Luddenham Advanced Resource Recovery Centre Submissions Report

Prepared for Coombes Property Group & KLF Holdings
May 2021

Submissions Report

J190749 RP38

APPENDIX C -PRELIMINARY CONCEPT
ELIZABETH DRIVE/ADAMS ROAD INTERSECTION

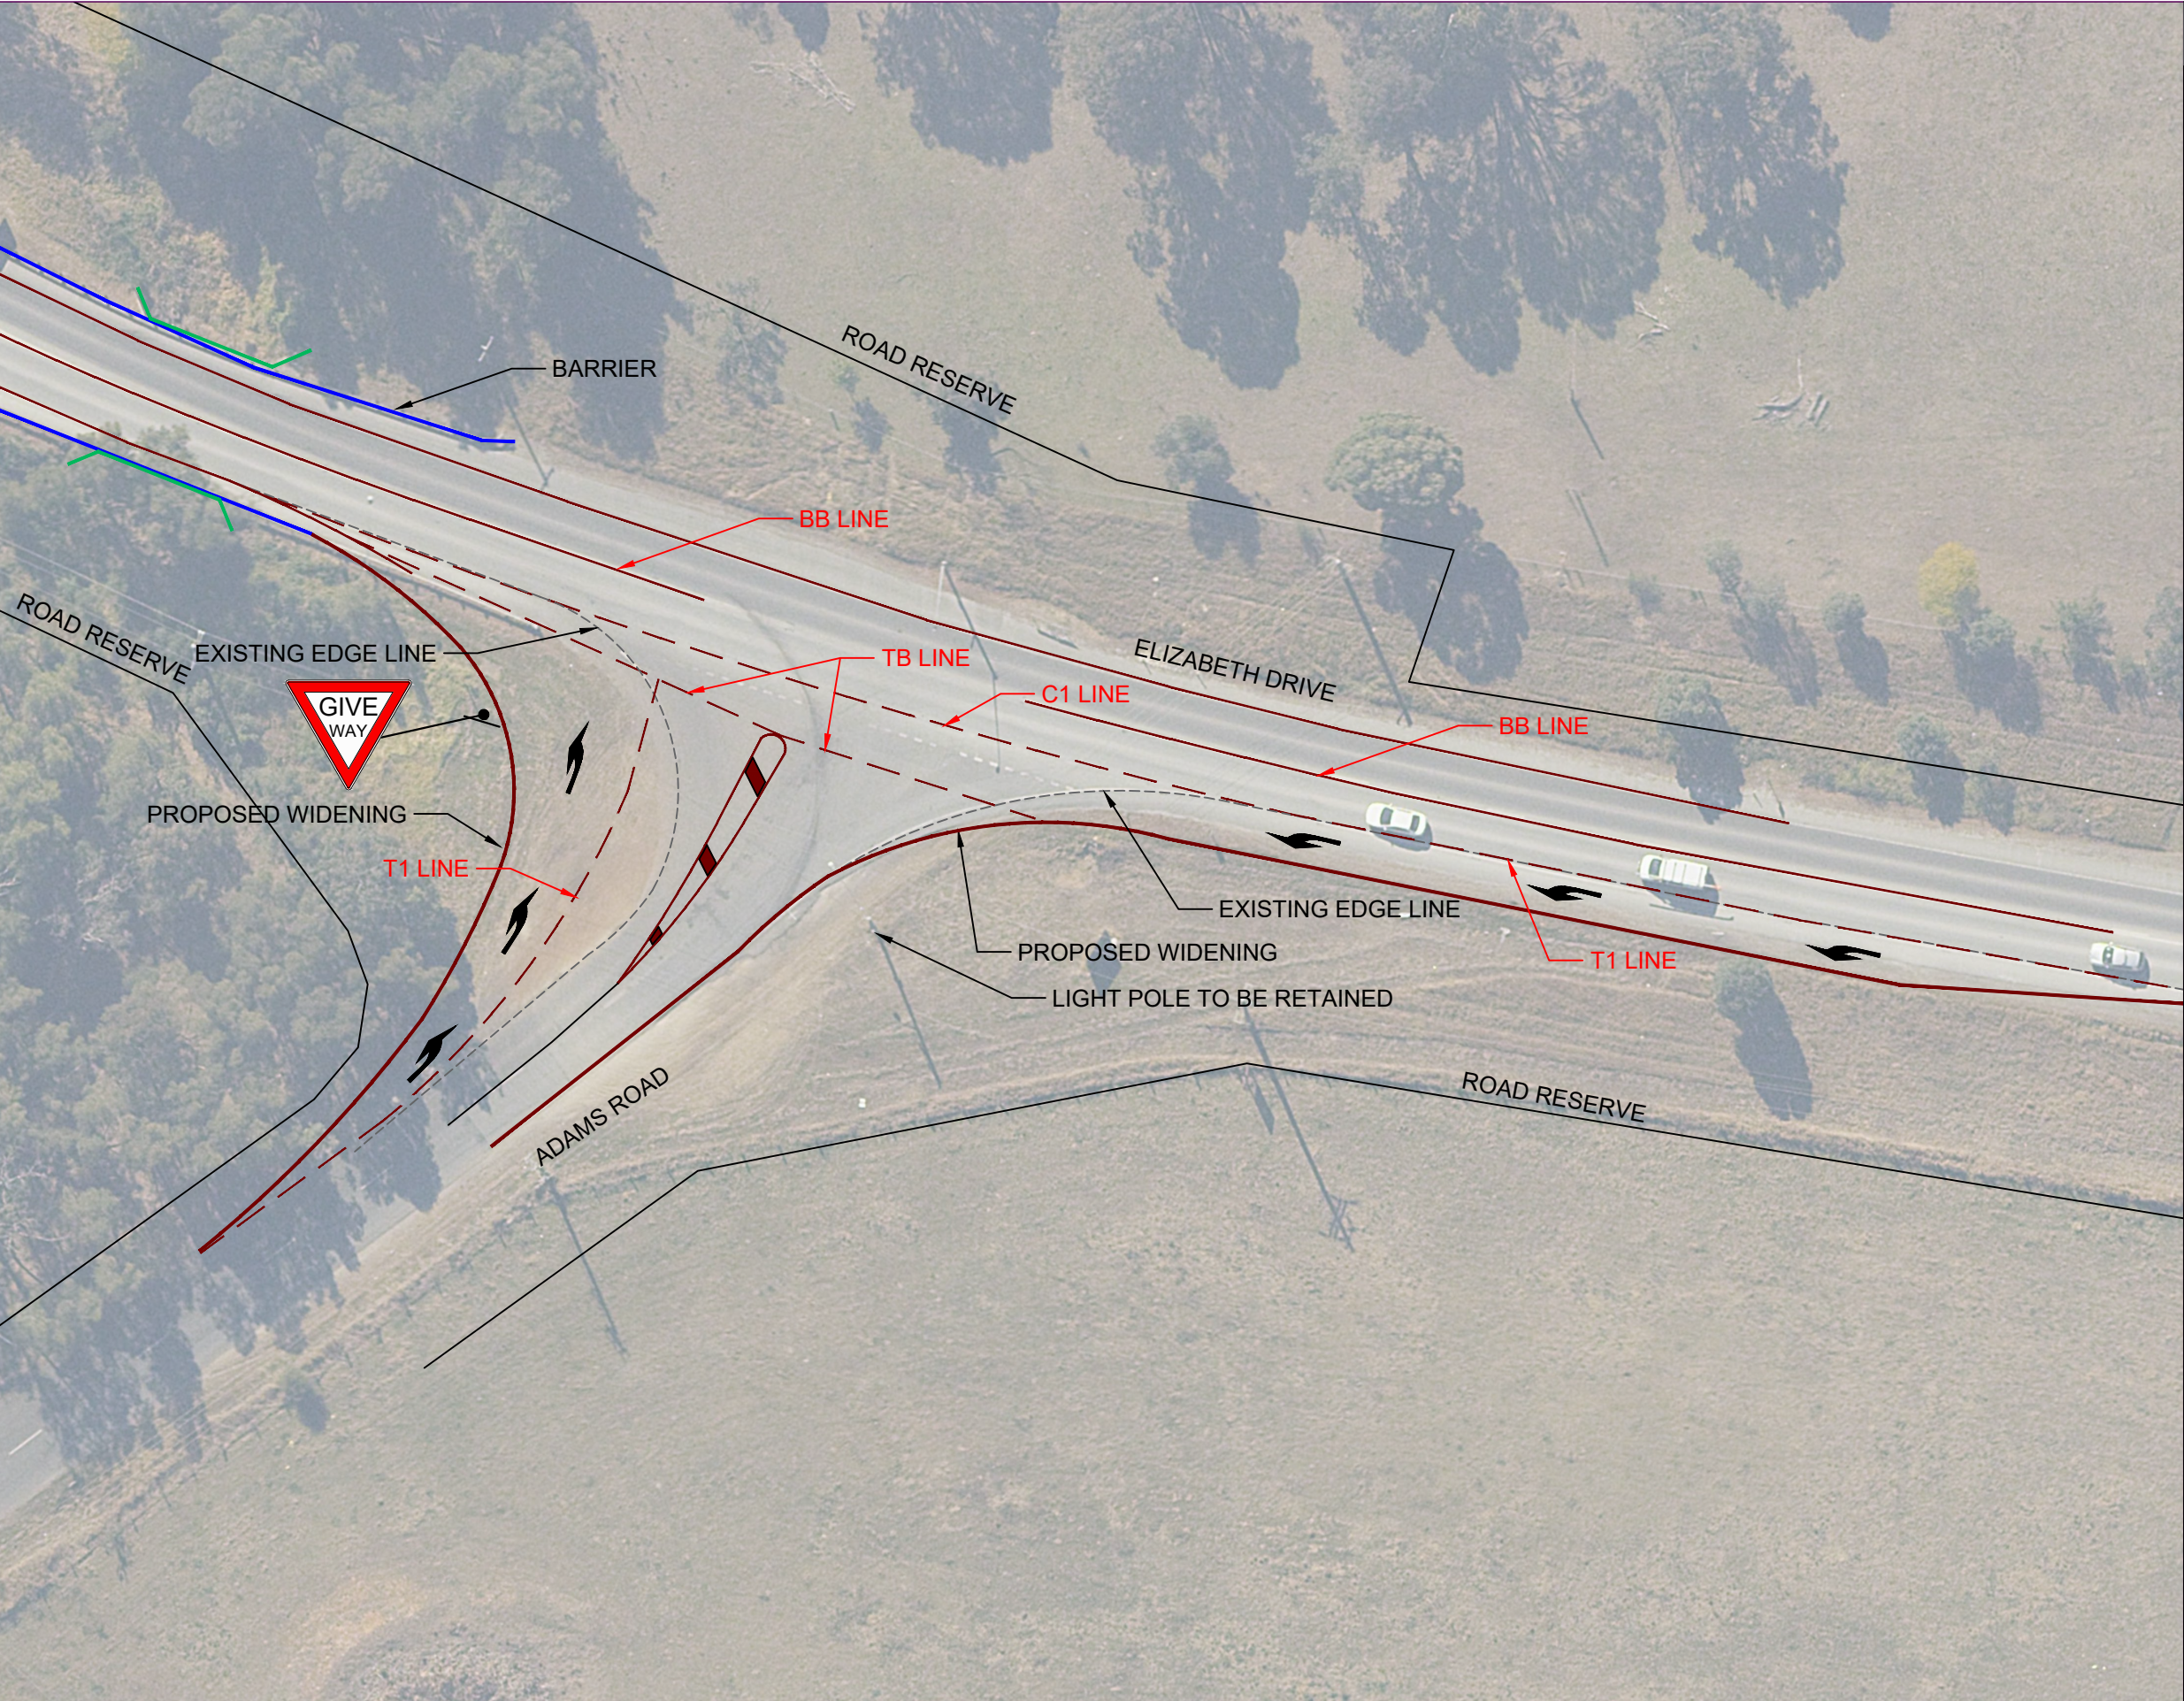
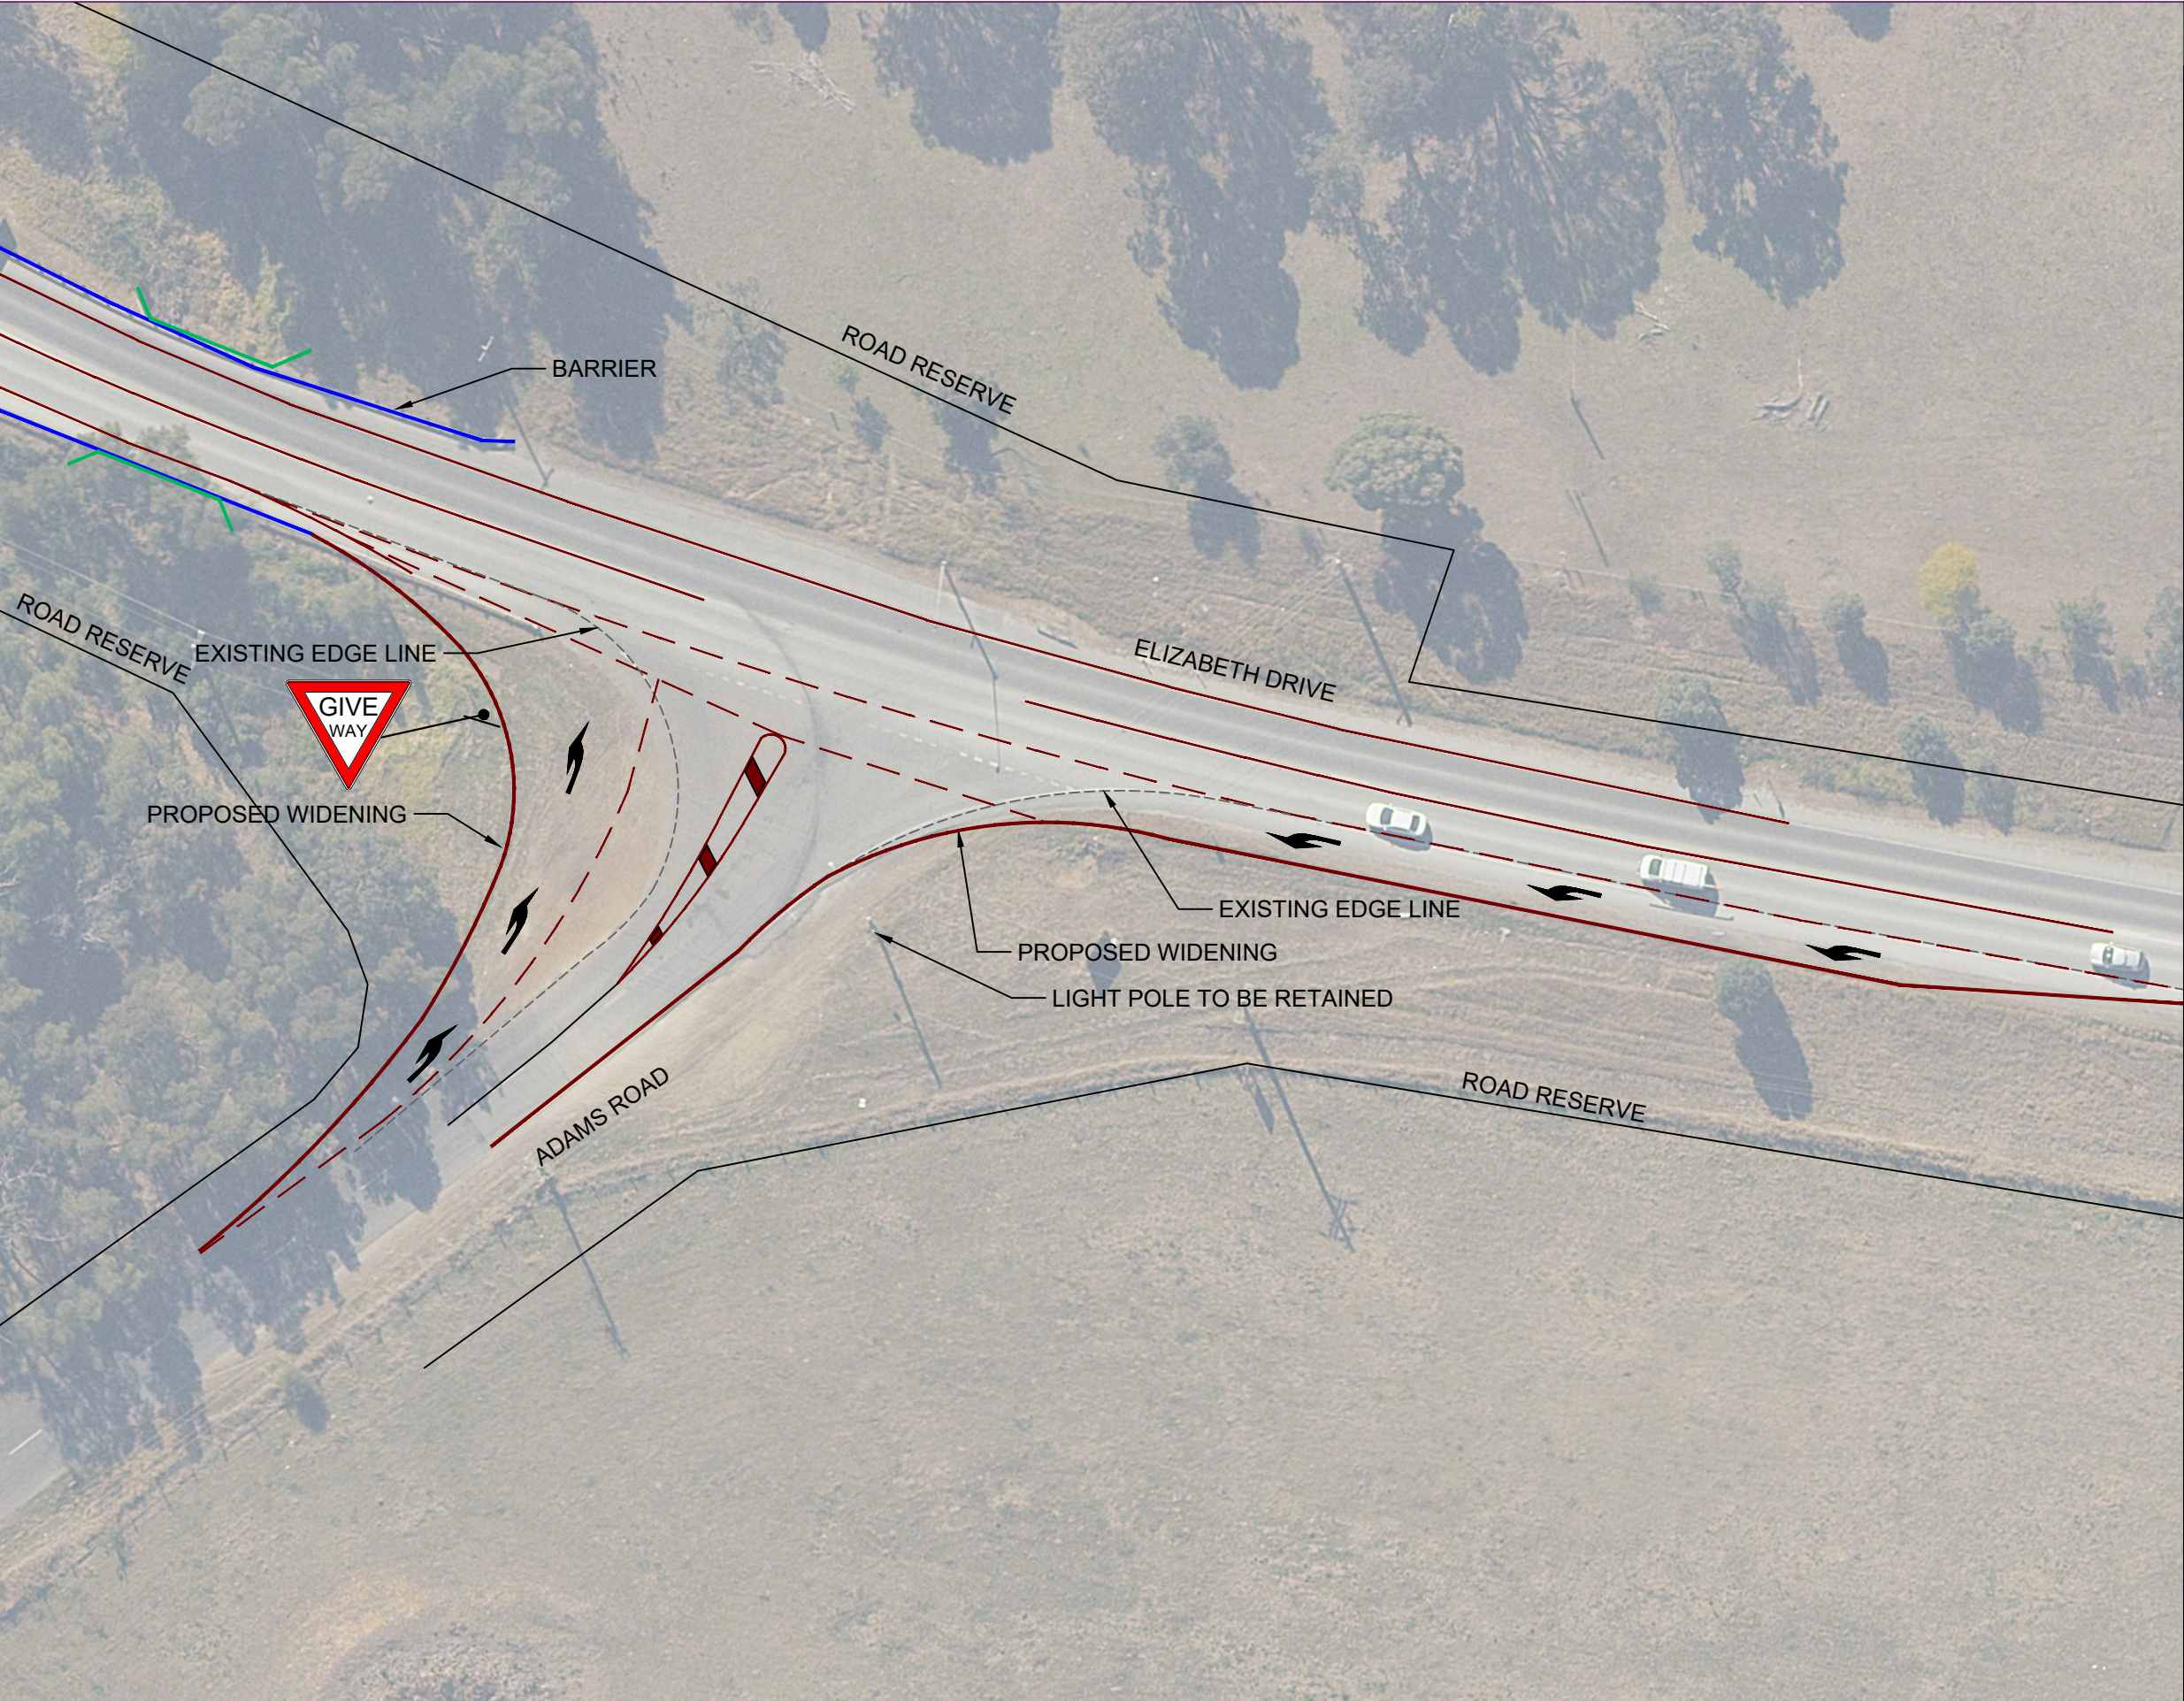
Consultation with TfNSW and Liverpool City Council has continued since the submission of the EIS. TfNSW raised safety concerns in relation to the right hand turn for heavy vehicles into Adams Road from Elizabeth Drive.

- Upgrade of turn treatments at the Elizabeth Drive/Adams Road intersection and restriction of the right-hand turn from Elizabeth Drive west into Adams Road as follows (refer preliminary concept sketch in Appendix C):

- provision of a 90 m deceleration left-hand turn lane into Adams Road to meet the Austroads guidelines;
 - provision of short left hand turn lane on Adams Road into Elizabeth Drive to minimise queuing on Adams Road;

- widening of existing Elizabeth Drive/Adams Road intersection to accommodate B-double swept paths; and
 - prohibiting the right-hand turn from Elizabeth Drive west into Adams Road for inbound ARRC vehicles –requiring these vehicles to access the ARRC using The Northern Road and the Adams Road south of the ARRC.
